An
Bord
Pleanála

Inspector's Report ABP-305343-19

Strategic Housing Development

Demolition of five structures on site and construction of 406 residential units; childcare facility; commercial unit; reservation of a school site; new vehicular, cycle and pedestrian access from Main Street; continuation of Newcastle Boulevard forming part of east-west link street; new public park and associated site development works.

Figure 11.6 Hedges to be removed due to construction

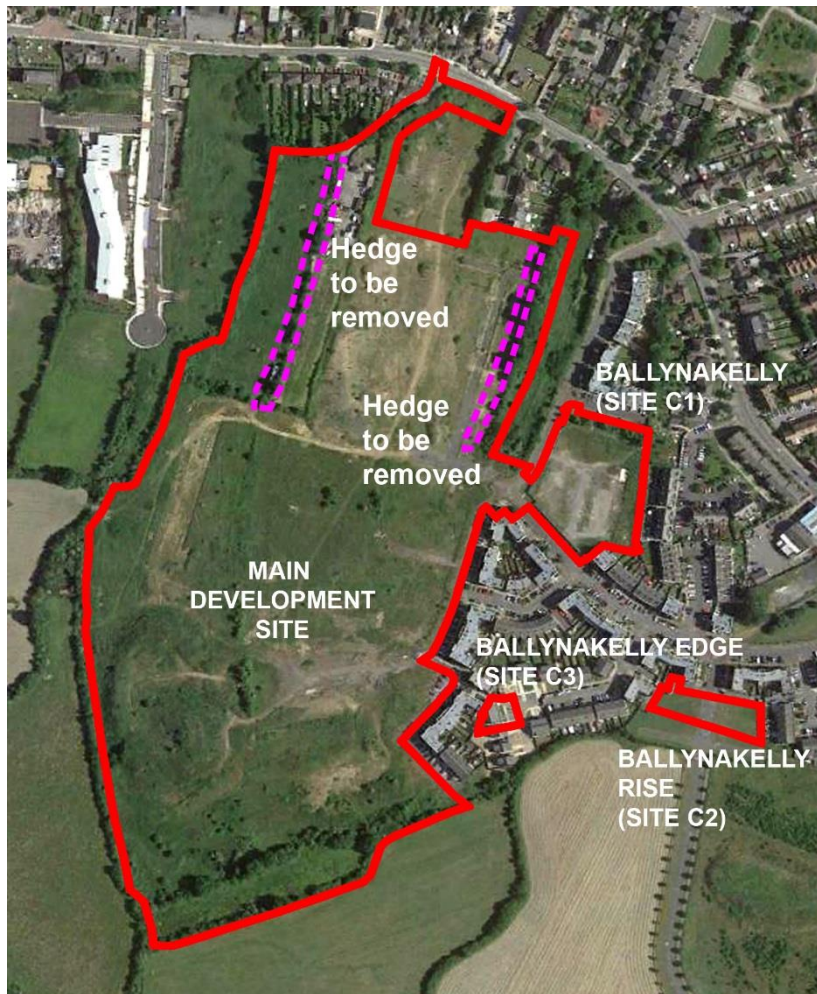
- Trees and Hedgerows: strong desire to retain burgage hedgerows within the site, which have been in place for over 700 years and are of national importance

10.3.3. I note the alterations undertaken since the pre-application consultation process. However, I still have concerns with regards the layout of the proposed scheme. I note section 28 ministerial guidelines in this regard, in particular the Sustainable Residential Development in Urban Areas- Guidelines for Planning Authorities and the associated Urban Design Manual, which sets out 12 criteria, drawn up to encapsulate a range of design considerations for residential development. I give particular focus in this instance to Criteria No. 1 Context and Criteria No. 6 Distinctiveness. It is noted that the proposed development, if permitted would result in the clearance of burgage plots which have been in place for over 700 years and which are regarded as being of national importance. These burgage plots are, to my knowledge a type of medieval allotment; long and narrow plots that were situated at the back of, and the same width as street facing properties. It is my understanding that the burgage plots in Newcastle are particularly well-preserved examples. The development as proposed will also remove other green infrastructural elements, which support a number of species including protected bat species. The LAP has extensive information, policies and objectives on how existing burgage hedgerows can be retained and incorporated successfully into development and promotes the retention, reinstatement and incorporation of them, where feasible into new schemes. However, I would draw the attention of the Bord to the fact that the indicative layout for this site, as set out in the LAP, is not in my opinion the optimum/most creative layout achievable when one is trying to preserve/reinstate these hedgerows.

landscaping often balances out the loss of such natural features, and this is often considered acceptable in such proposals. However, in this instance the importance of these hedgerows is noted and I refer the Bord to the report of the Heritage Officer of the PA in this regard. It states that the medieval significance of the area is reflected on-the-ground by the remaining planimetric layout of the field patterns into burgage plots. These long linear plots reflect the landownerships patterns invested in tenants of the local Anglo-Norman manor, stretching away from the Main Street of the village. The proposal before me pays little regard to these burgage plots, with the layout appearing to take little cognisance of their existence.

Replacement/reinstated hedgerow is proposed, however I consider this to be little more than lip service. The reinstated hedges in the most part are to form the boundary of private property, providing a boundary between rear garden areas, removed from the public domain. As these reinstated hedges will be located within private property, there will be little/no control over them into the future and in all likelihood may be removed/replaced at the earliest opportunity. In my opinion, the context of the site was disregarded in the layout of the proposed scheme, with no indication that the scheme evolved naturally taking cognisance of its surroundings. This is contrary to the provisions of Criteria No. 1 of the aforementioned Urban Design Manual. In my opinion, the layout before me is not an appropriate response to the natural characteristics of the site. The layout could have incorporated some, if not all of these important historic burgage hedgerows into publically accessible areas of open space. The scheme could have been designed with a vertical emphasis, reflecting the linear form of these hedgerows. This did not occur. It appears to me that the reinstatement of hedges, largely in inappropriate locations, was an after-thought.

Figure 3.1 Proposed Site Layout Plan

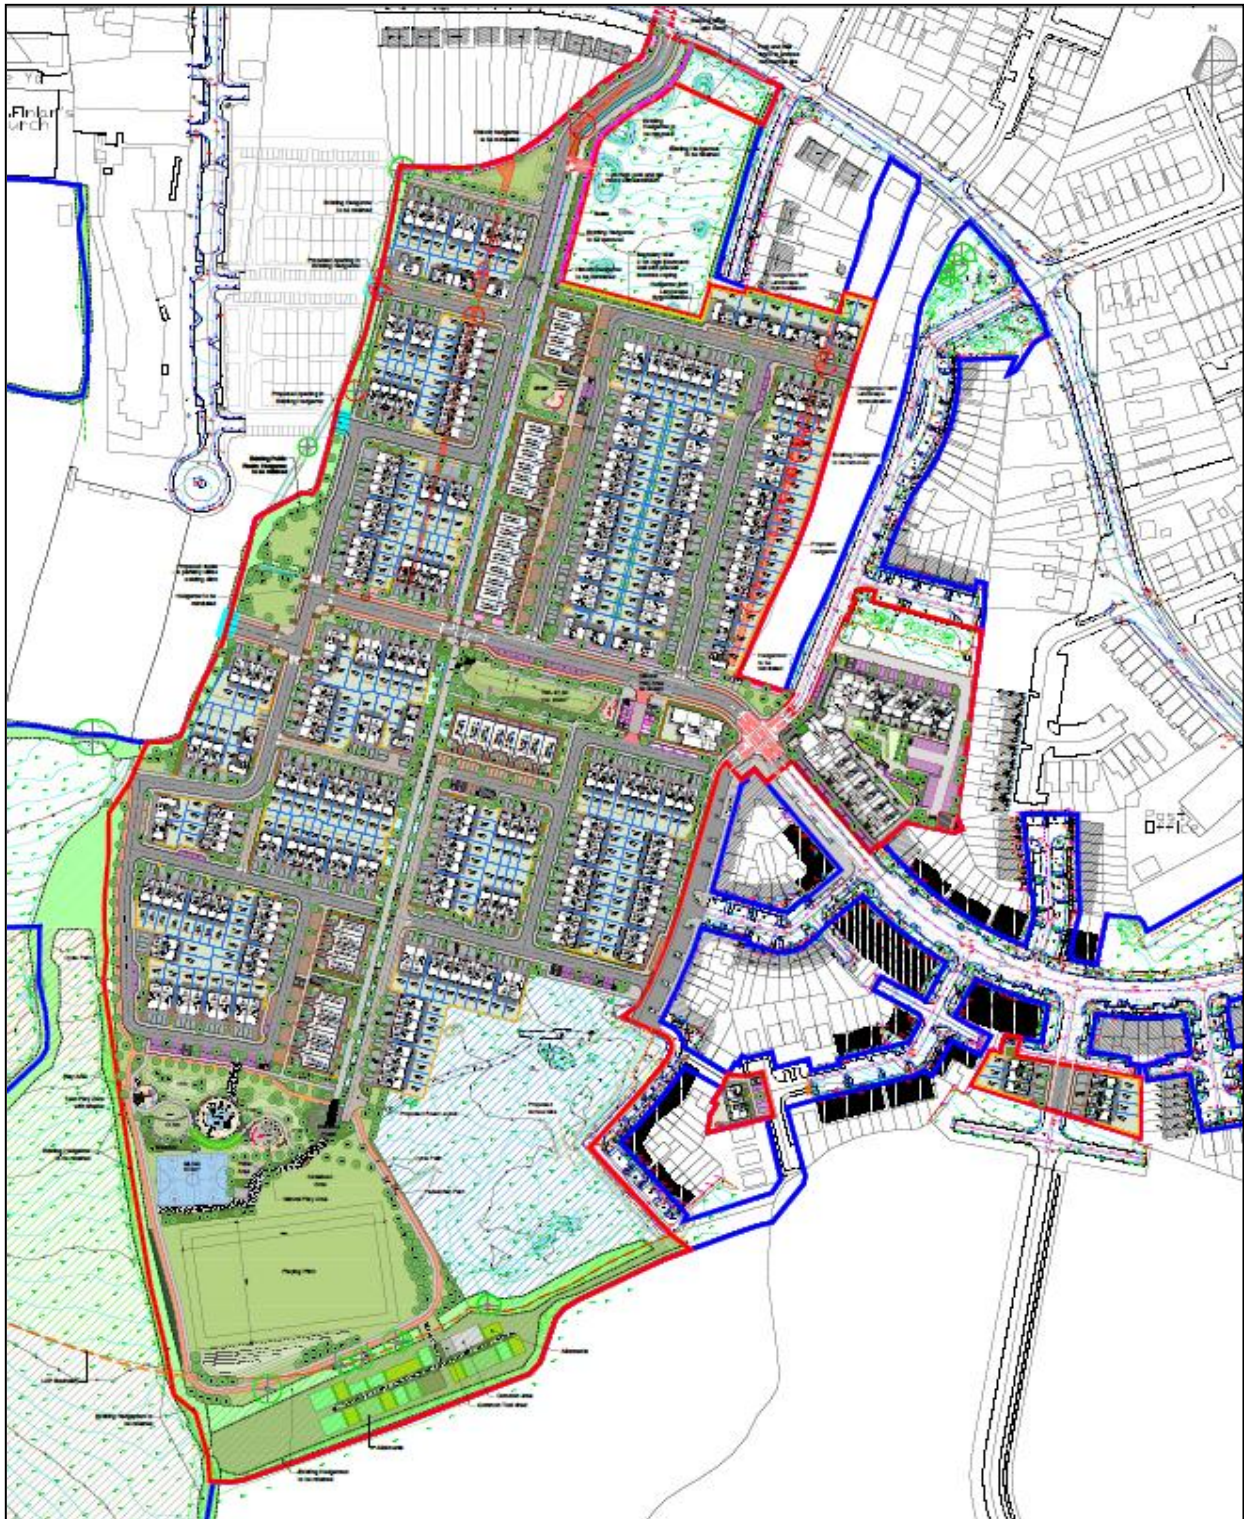
- Layout: proposed layout deviates from that indicated in the Newcastle LAP- increased density such that some units may appear cramped within context of the site- concerned that layout and configuration would adversely impact on residential amenities of future residents, with potential overshadowing and visual intrusion; concerns regarding depth of gardens; regard to site levels; long-term visual impacts of marketing suite

10.3.6. There is the potential to create character areas, a sense of place, a greater variety of unit type and areas of higher/lower density in accordance with the principles of the Urban Design Manual. This has not been satisfactorily achieved in this current proposal. The entrance to the scheme is weak and I note the extent of 2 metre high walls located along the main access roads and alongside the main pedestrian/cycle routes through the scheme. As one travels either by car, bicycle or on foot, one will be looking into the rear garden areas of properties with all that that entails. The provision of two-metre high walls at such key locations is considered inappropriate and a poor design response. It would have been a superior response to have residential units fronting directly onto the roadway with rear gardens removed from public view. In addition, I note that in terms of the proposed apartment/duplex units at the Ballynakelly infill site, it is noted that the area surrounding the units is dominated by surface parking.

- 10.3.10. Public open space, which comprises 23.6% of overall site area, is provided by way of a larger area of open space to the south of the main site, together with smaller pockets of open space scattered throughout the development. Allotments are proposed to the south of the site and these are to be welcomed, subject to condition. A number of facilities are proposed within the larger space to the south including playing pitch, MUGA and play area. The planning authority state that the playing pitch is of insufficient size to cater for GAA matches and would need to be reoriented. Again, this is an unnecessary failing of the scheme. Insufficient detail has been submitted in relation to the design of the open spaces. Street trees are proposed on private property which is again not desirable and proposed trees are considered to be of insufficient size. While it is preferable to have this information for assessment at application stage, if the Bord is disposed towards a grant of permission, the matter could be dealt with by means of condition. It is noted that the natural play area, situated to the west of the childcare facility, is surrounded on three sides by roadways, again this is not desirable.

- 10.3.15. I consider that this development has a number of design and layout issues that require addressing. A creative layout could be easily achieved to incorporate the burgage plots into the scheme, making it a distinctive and attractive place in which to live, reflecting the history of the area. The design of the residential units is such that there is little in the way of character areas. In terms of unit type/size, I am of the opinion that as proposed, it is essentially providing more of the same for Newcastle, which already appears quite well served with such three and four bed properties. If the Bord is disposed towards a grant of permission, an option would be to omit some of the units proposed and amend the layout, providing for a revised proposal. I did consider this option in my assessment, however I am not recommending it in this instance. This is a greenfield site, with little in the way of substantial site constraints. Some of the burgage hedges could easily be incorporated into a creative layout. Given the circumstances, I consider that the principle of 'retrofitting' units/layout by condition is not appropriate in this instance. I consider that the proposed scheme needs a complete re-assessment, which should
